City of Albuquerque

RE: STORY ROCK SUBDIVISION UNIT 1 & 2 (F-11/D9)
Engineers Certification For Release of Financial Guaranty
Engineers Stamp dated 8/30/2000
Engineers Certification dated 8/21/2002

**Re: Final Certification of Drainage for Release of Financial Guarantees,
Story Rock Subdivision, Phases One and Two (F11/D9)**

STORY ROCK SUBDIVISION
GRADING AND DRAINAGE PLAN-SHEET "A"

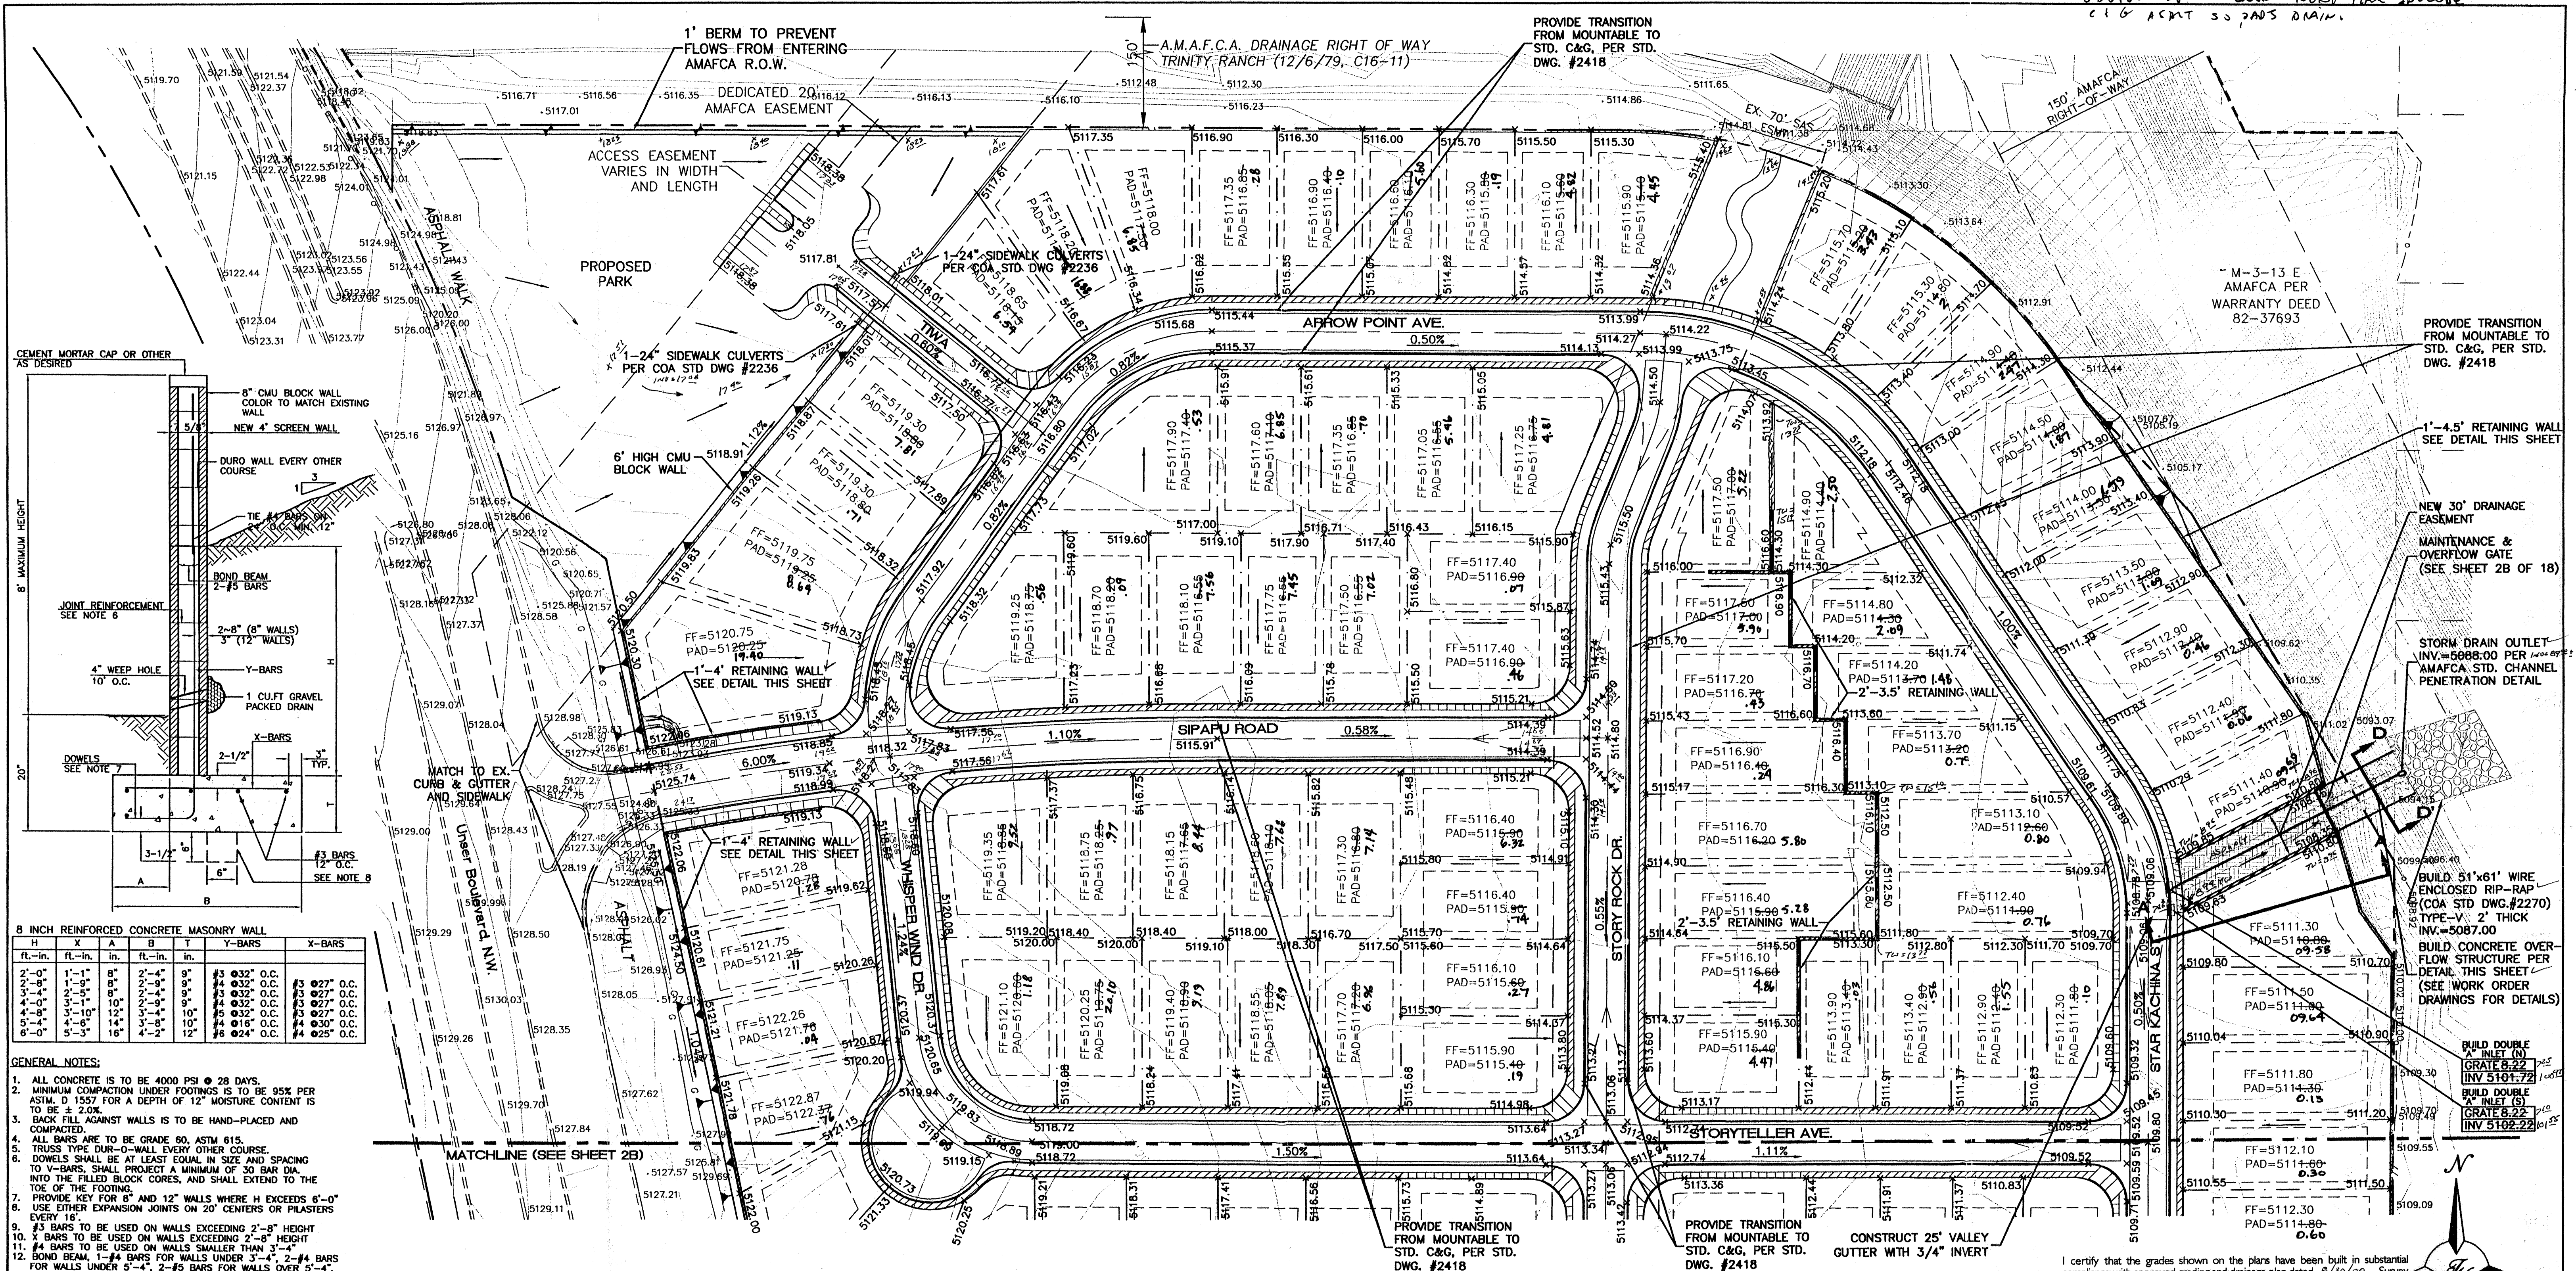
At first glance on your certification it appeared that the difference in grades was greater than 18"; However upon a site inspection the grades appeared to allow the water to drain to the street. In the future, please certify street asbuilt elevations as well as pad elevations to avoid any confusion, and allow for a prompt acceptance of the certification and release of financial guaranty.
